Martin Nugent  
01254 828060  
D3/11/0547

**Outline Planning Application, Ribble Valley District  
3/11/0547 24 Chatburn Park Drive, Clitheroe**

Drawing Title  
**Proposed Plans and Elevations**

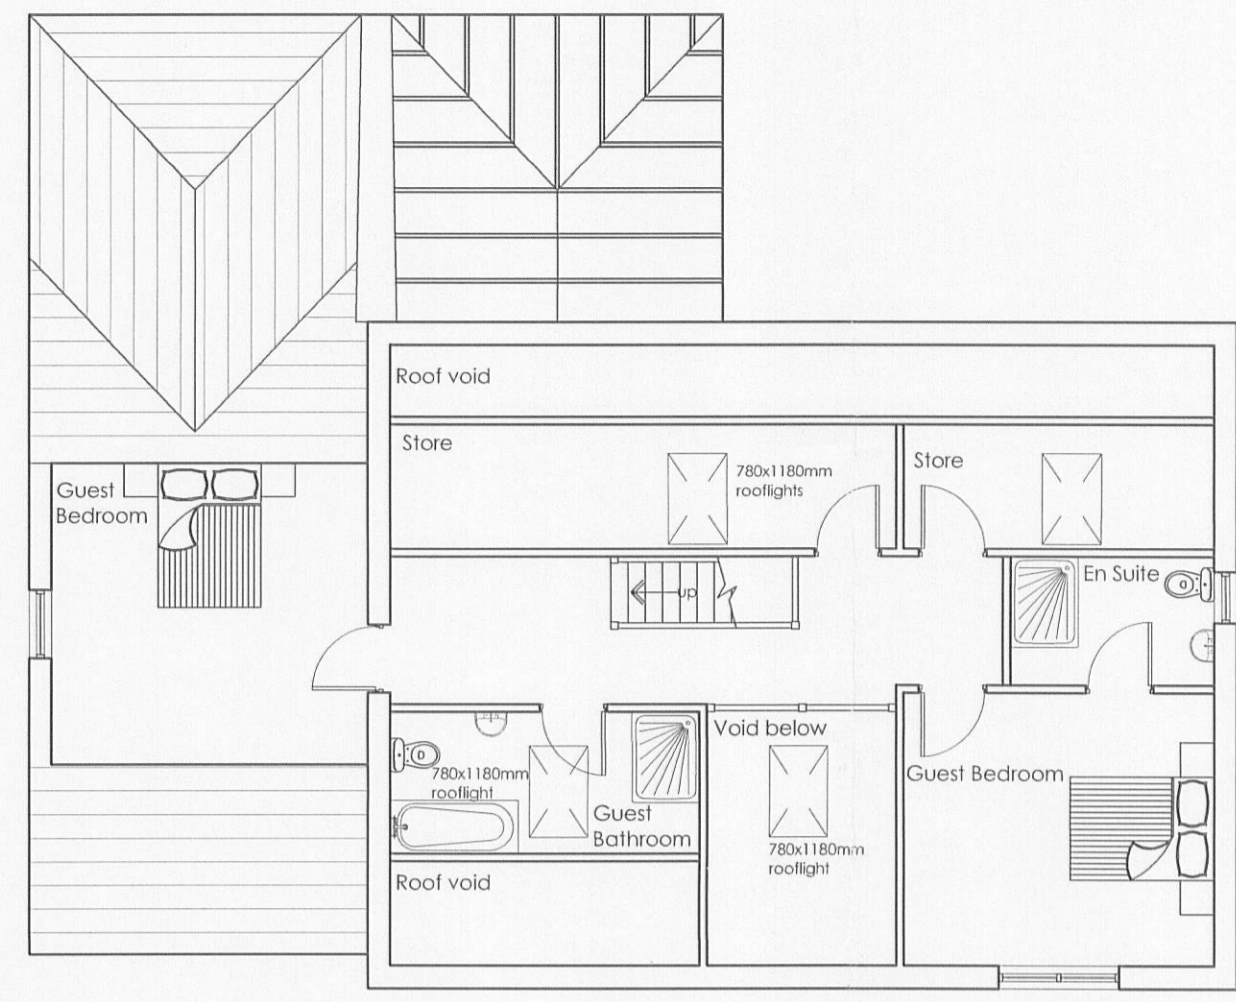
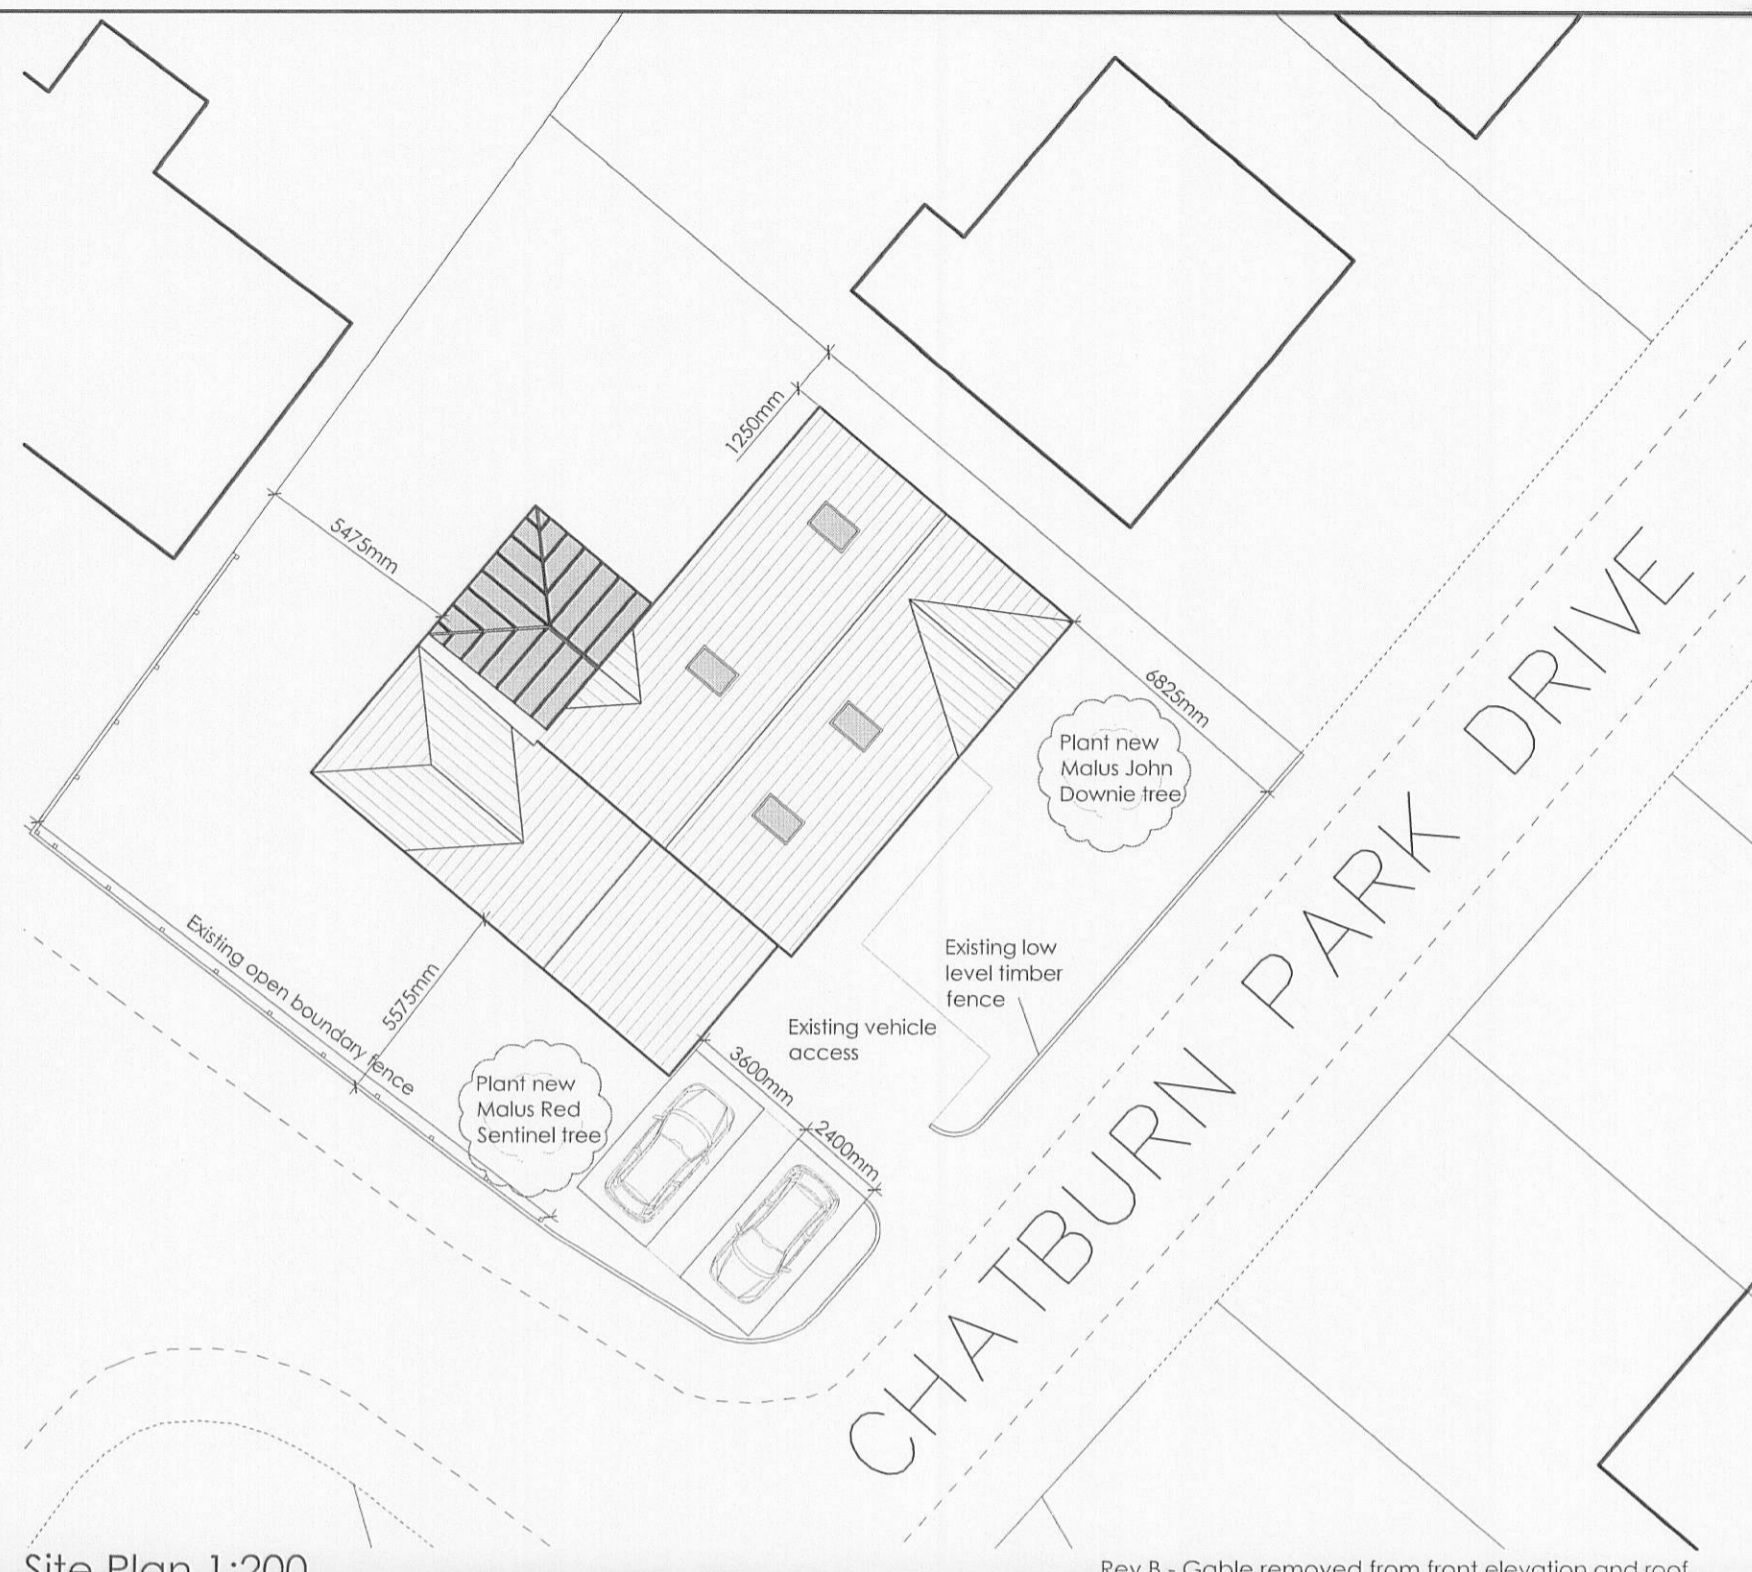
The residential layout provides for three off road parking spaces to the rebuilt property. One of the spaces shown is from an integral garage. In order to retain the use of this space for garaging it would be appropriate to include a Condition prohibiting the future development of this area for residential space or for exclusively storage purposes.
